DRB Application No.: 10DRB-70137 Project # 1008191  
Project Name: BARON BURG HEIGHTS  
Agent: FORSTBAUER SURVEYING LLC Phone No.: \_\_\_\_\_

10DRB-70136 MAJOR - VACATION OF PUBLIC RIGHT-OF-WAY  
10DRB-70137 MINOR - PRELIMINARY/ FINAL PLAT APPROVAL

FORSTBAUER SURVEYING LLC agent(s) for ELEANOR JANE CARLTON, TRUSTEE request(s) the referenced/ above action(s) for a portion of BELL AVENUE SE and CARDENAS DRIVE SE adjacent to and including Lot(s) 12, SHIRLEY'S SUBDIVISION of Block 3, **BARON BURG HEIGHTS**, zoned R-3, located on the northwest corner of CARDENAS DR SE and BELL AVE SE containing approximately 0.1683 acre. (L-18)

**RE: Lots 12 - 14, Block 3, Baron Burg Heights Subdivision**

Sketch Plat
 Lots 12, 13 & 14, Block 3
 Baron Burg Heights
 Bernalillo County, New Mexico
 City of Albuquerque
 February 2010

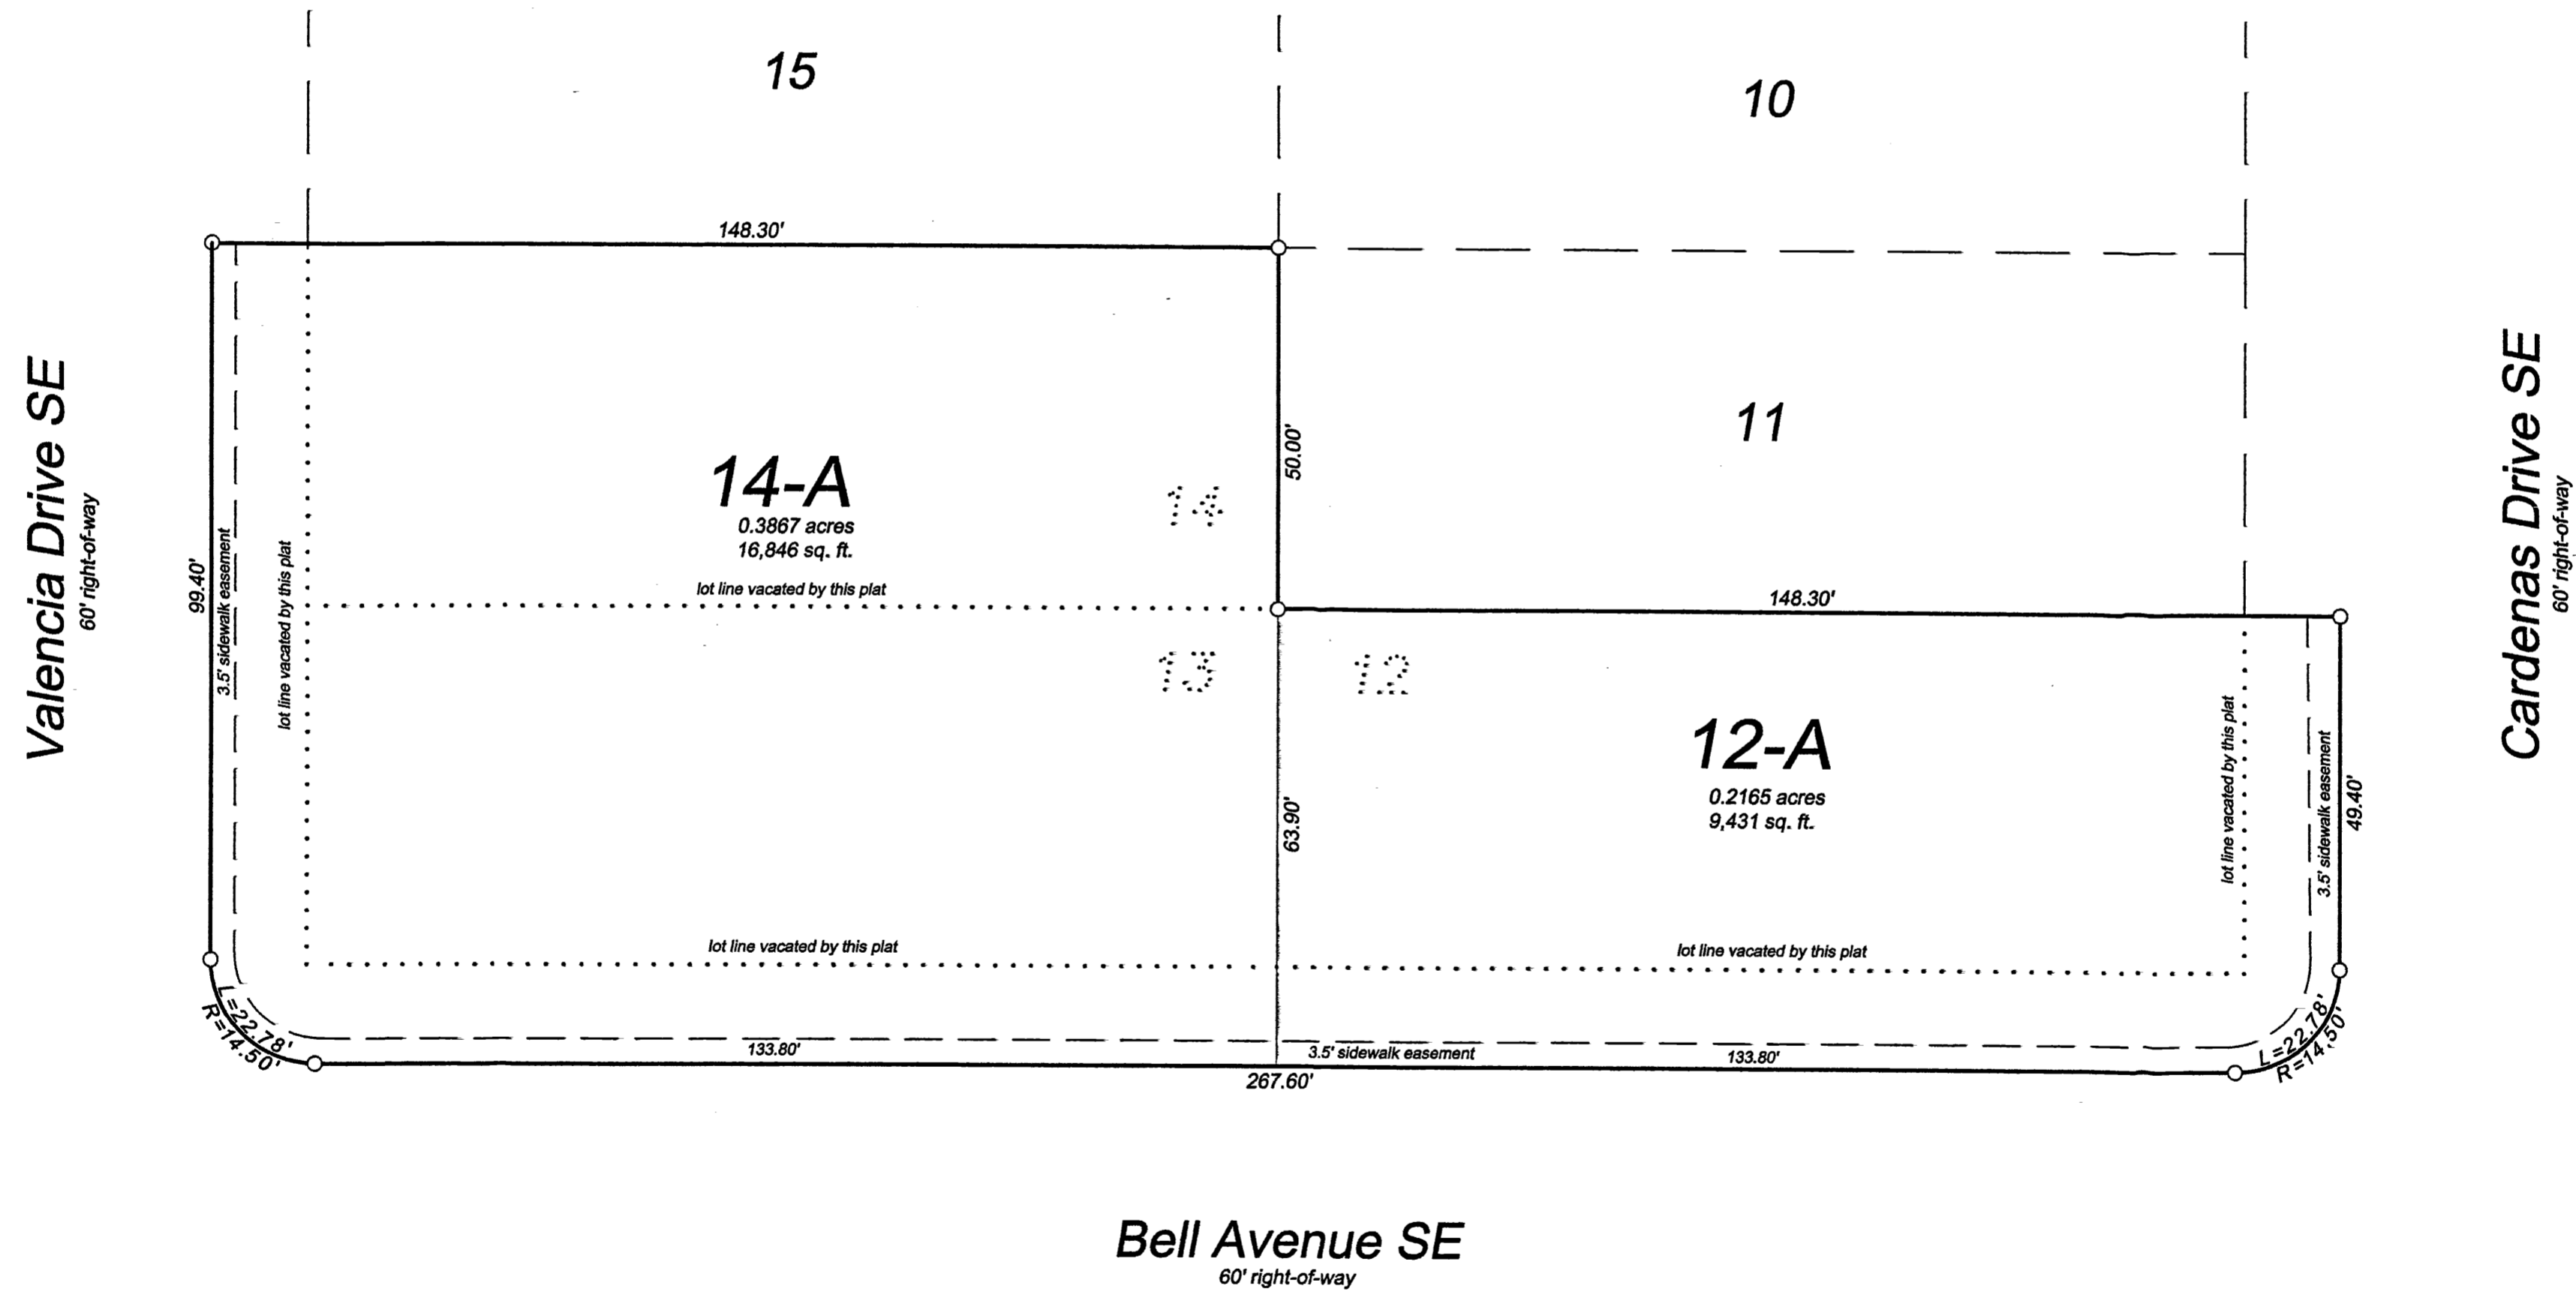
Please provide the number of existing dwelling units for each lot (maximum 30 per acre, or total of 10 for proposed lot 14-A).

It appears the maximum amount of right of way which could be vacated for each street would be 5 feet, in order to maintain a minimum (centered) right of way of 50 feet – refer to comments from Transportation Development.
